**Consultation Response from Mike Hibbert,  
KC Waste Strategy( Refuse & Recycling)**

**2023/91116 Land off, Primrose Lane, Hightown, Liversedge, WF15**

**Erection of 77 dwellings, with access from Darley Road and associated works**

**Responding Ref: WPN 23-022 (Revised)**

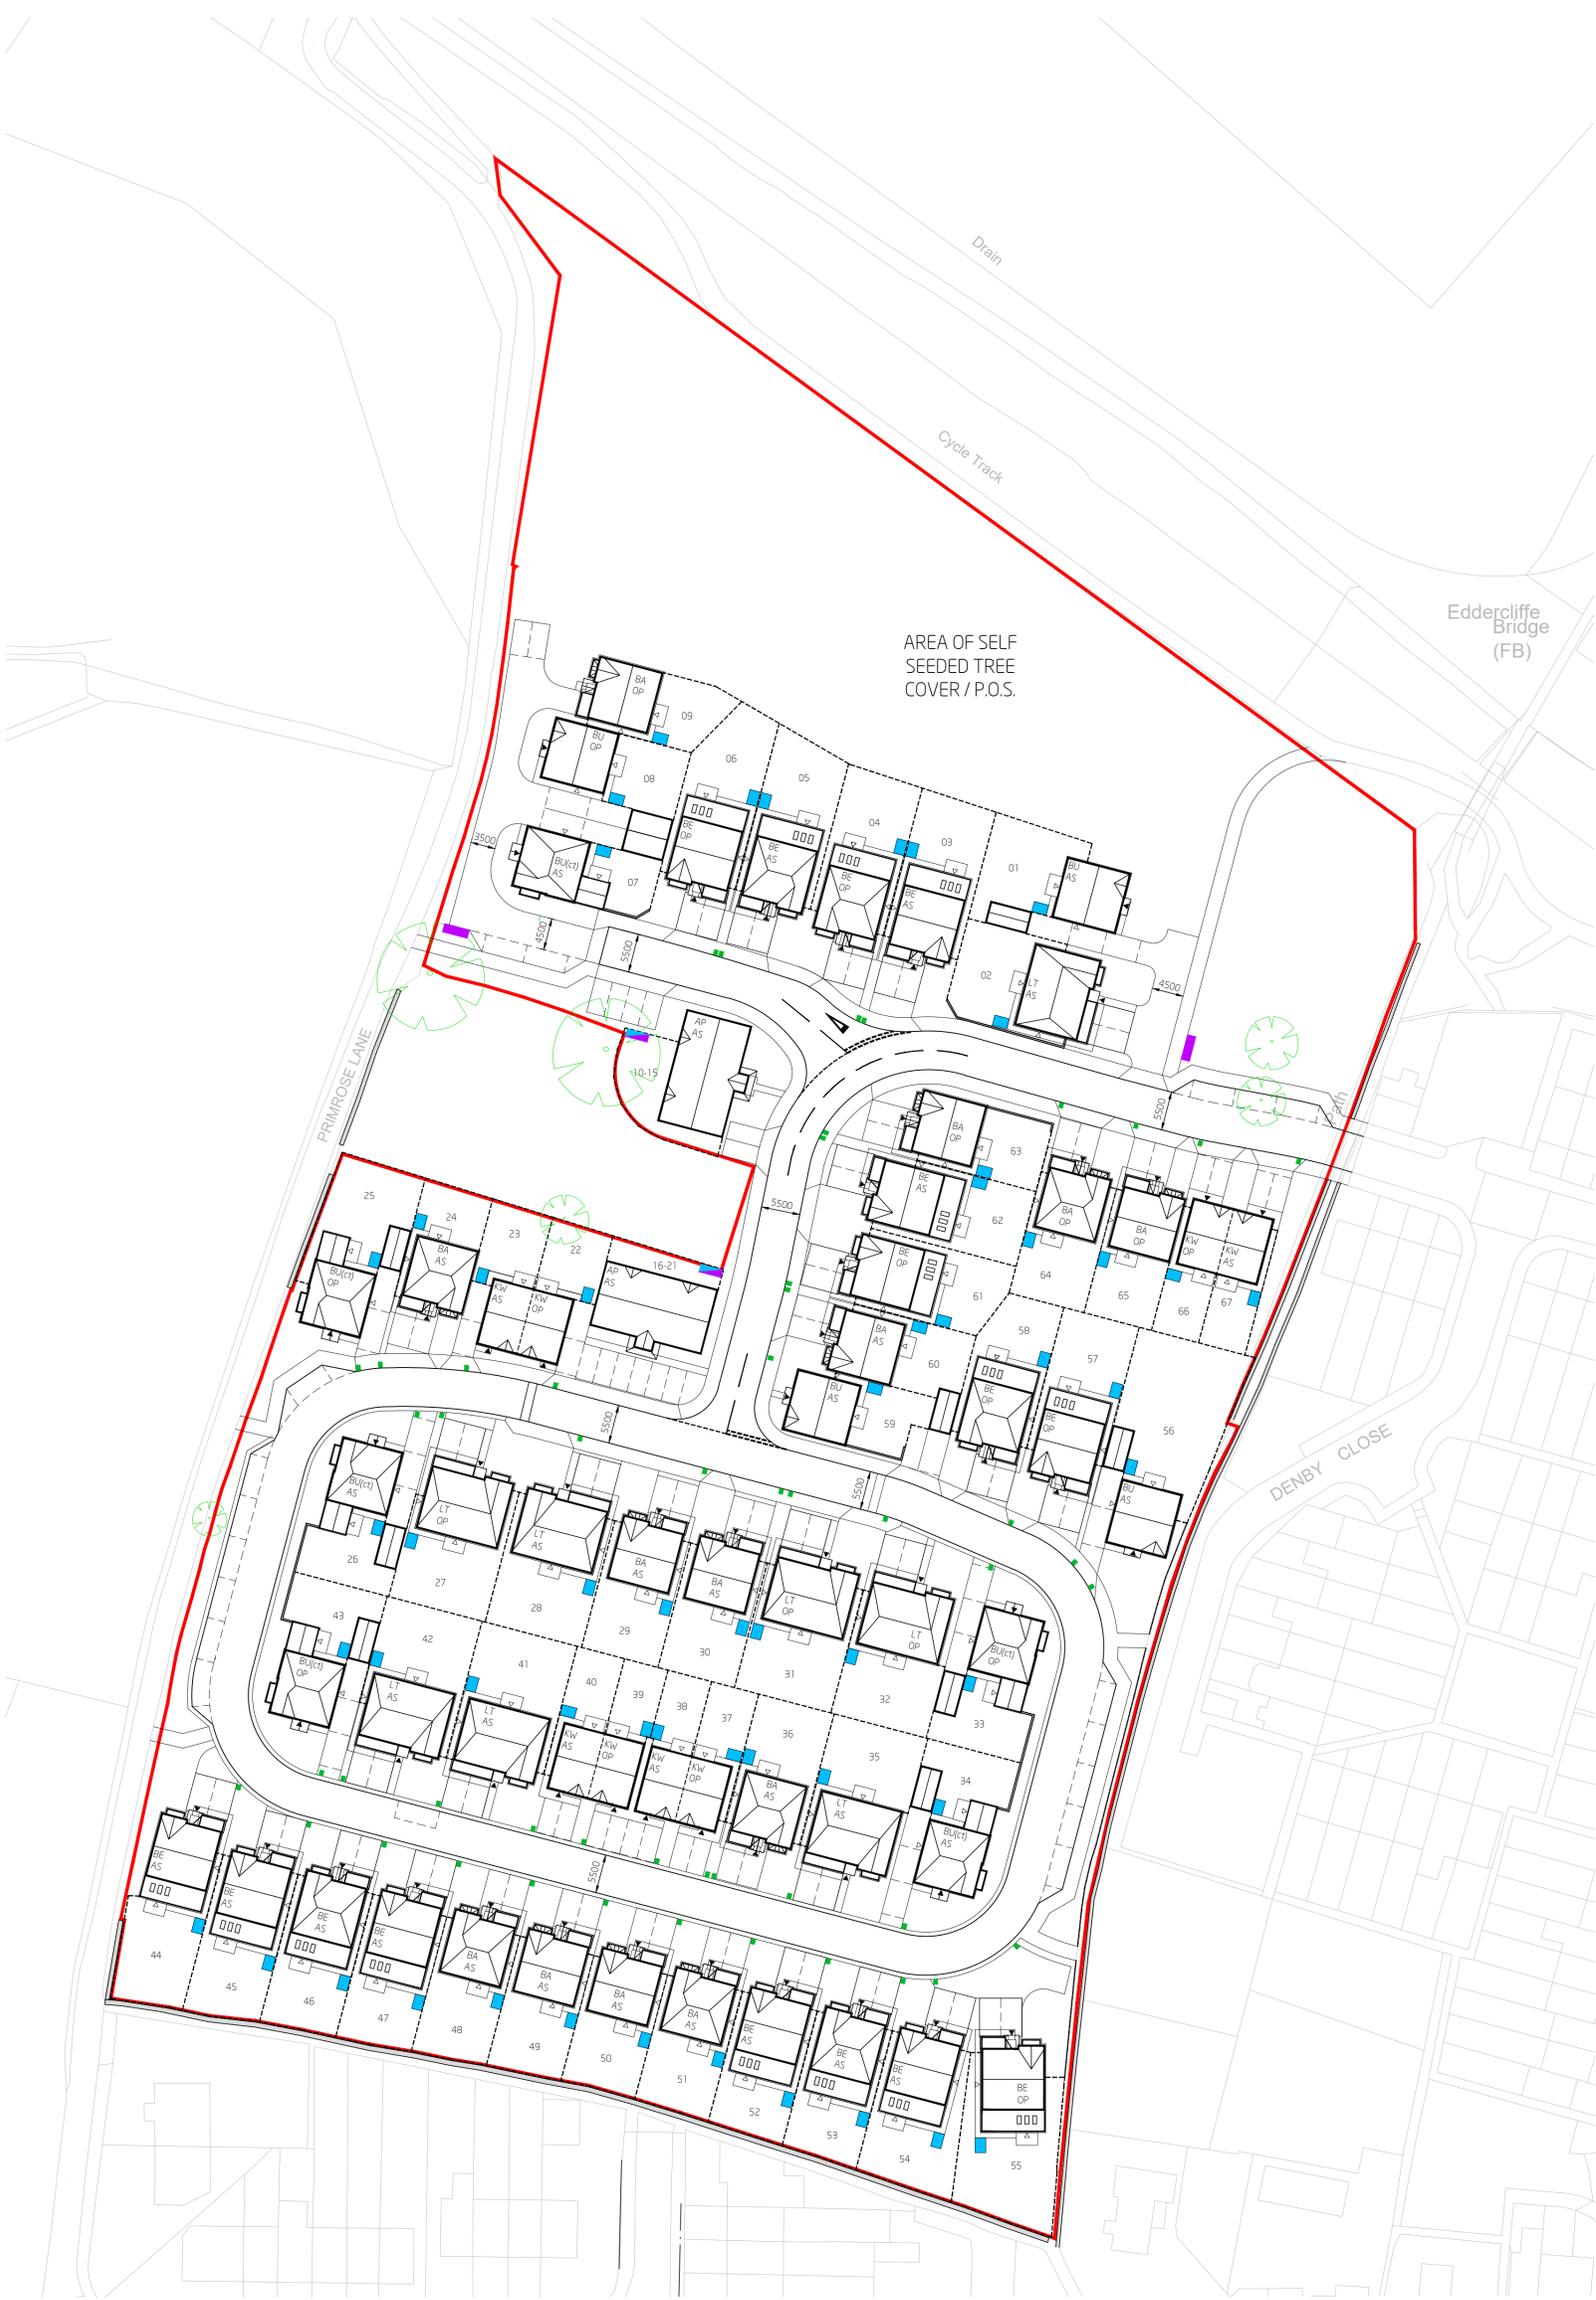
- Guidance indicates that the drag out distance from Bin Collection Points to the highway should be under 10m. On this basis the BCP's should be located nearer to the adopted highway e.g. Plot 1(potentially moved further south), Plots 8 -9 (potentially on the verge opposite Plot 10), and Plots 11-13 (potentially on the verge opposite Plot 14). The relocation would still enable the drag out distance for householders to be within the 25m limit specified in BS5906:2005

- It is recognised that individual bins for each dwelling in Apartment blocks on Plots 16-21 and 22-27 is not practical and provision of communal bins will be necessary. Consideration needs to be given to the fire risk presented by waste storage. Communal stores should be located either 6m away from the building or be constructed of suitable material to contain and prevent the spread of fire. See BS5906:2005, Building Regs 2010 Part H6 and CFP-A-E Guideline No 7:2022 F. The stores on the Plan appear to be within 1.5 and 2m of the buildings.

- There may be potential to relocate the bins stores for Plots 16-21 to the front of the property by moving the parking space to the rear and using this area. For plots 22-27 the bin store could be relocated to the eastern end of the parking area. Bin stores should be suitably screened to avoid impact on the Streetscene.
